KITTITAS VALLEY FIRE & RESCUE

I have reviewed the Notice of Application dated September 8, 2014 for Anderson Hay Non-Project Rezone (CP-14-00001 & RZ-14-00002) and have the following comments:

Anderson Hay and Grain Rezone : Existing Development

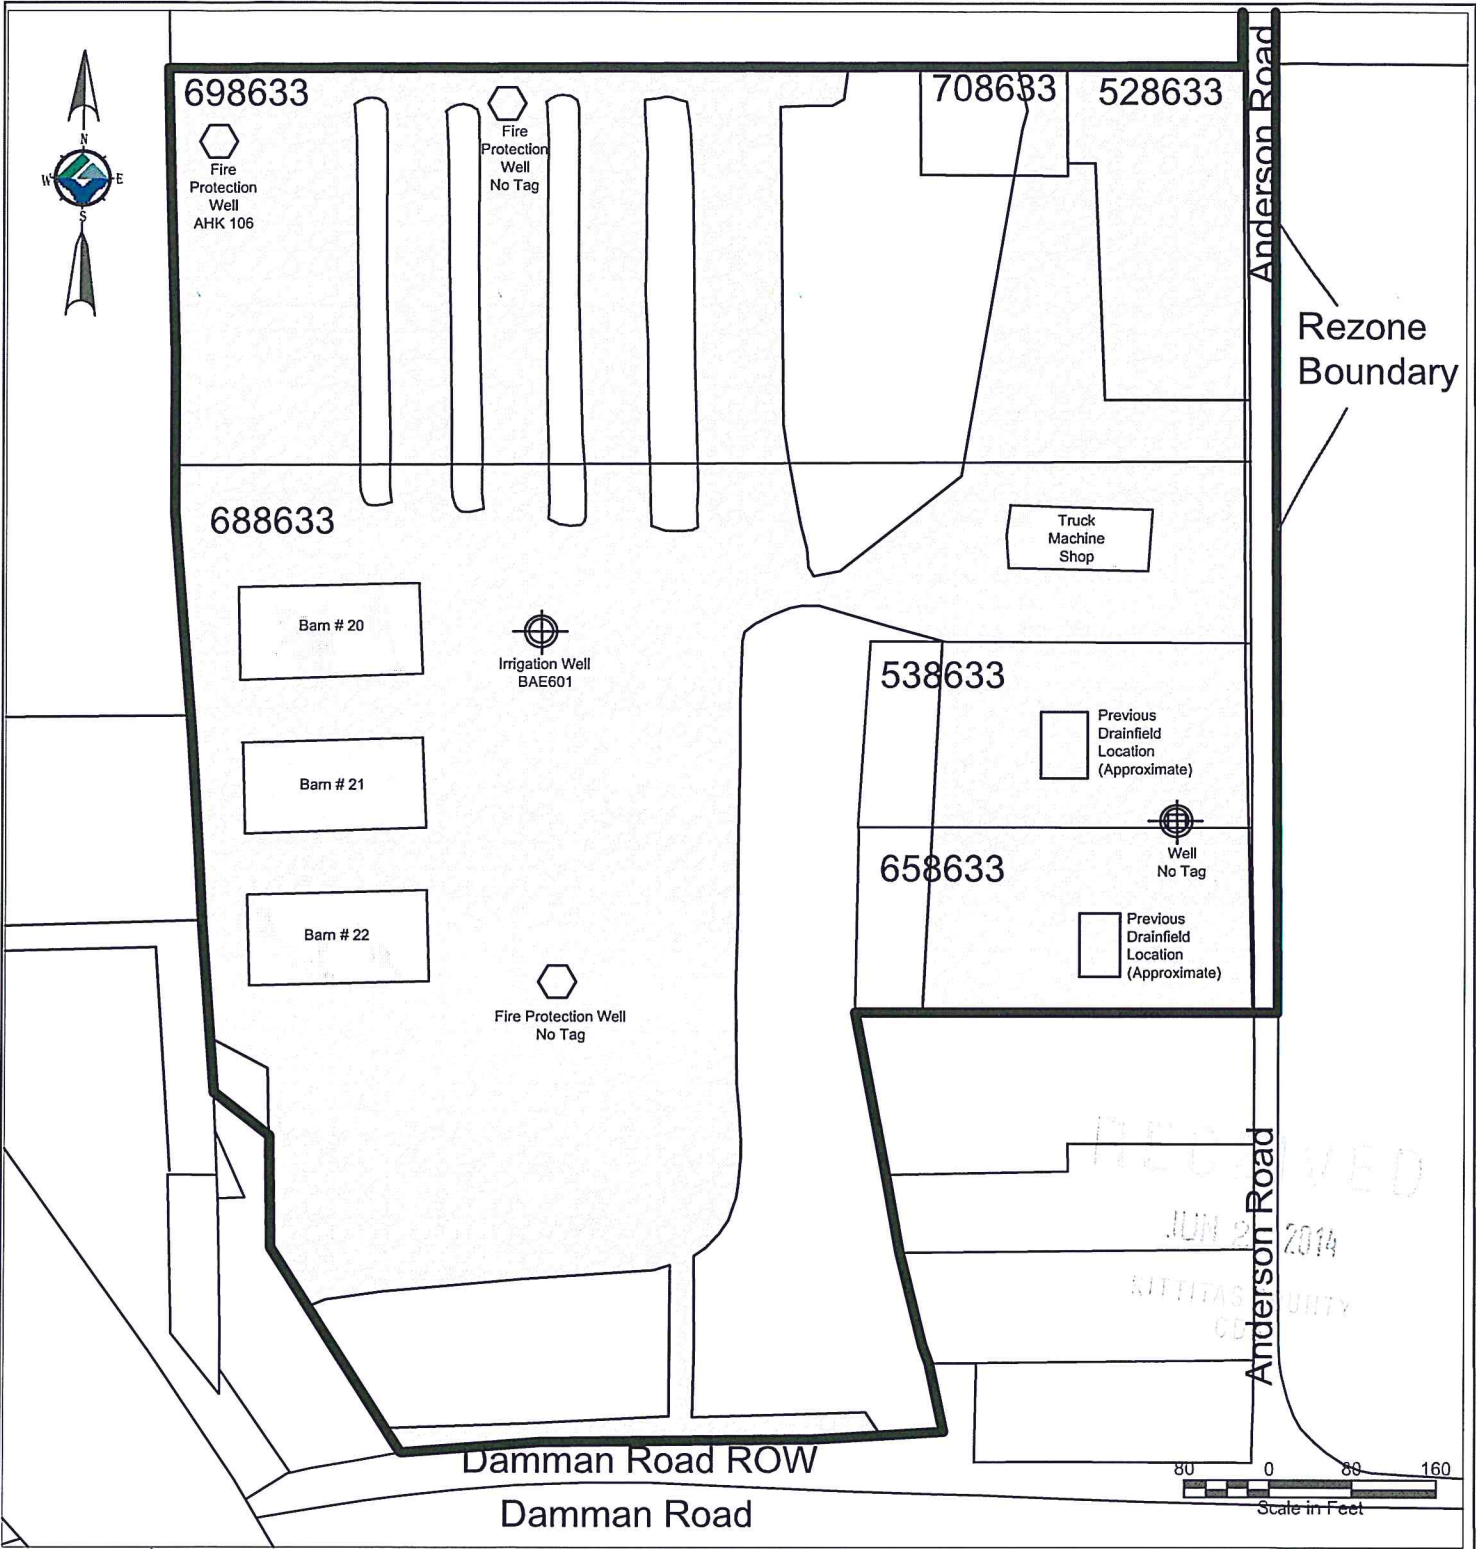
- The change in use for this property residential to commercial will increase demand on fire protection services. Adequate water supplies to this area are critical to protecting future life and property. The nearest hydrants are not located close enough to supply water to this property. On site wells provided by Anderson Hay are not sufficient at this time to provide adequate fire flows. Large property loss fires at Anderson Hay in the past highlight the need for improved water flow in this area. Additional commercial growth will only increase the need for adequate fire flows.
- Commercial growth in the City of Ellensburg to the east of this location has improved the infrastructure (water mains and fire hydrants) as required by the International Fire Code. These improvements reduce the costs of additional upgrades for this project.

It is my recommendation that fire hydrants be installed prior to any permits for construction being issued.
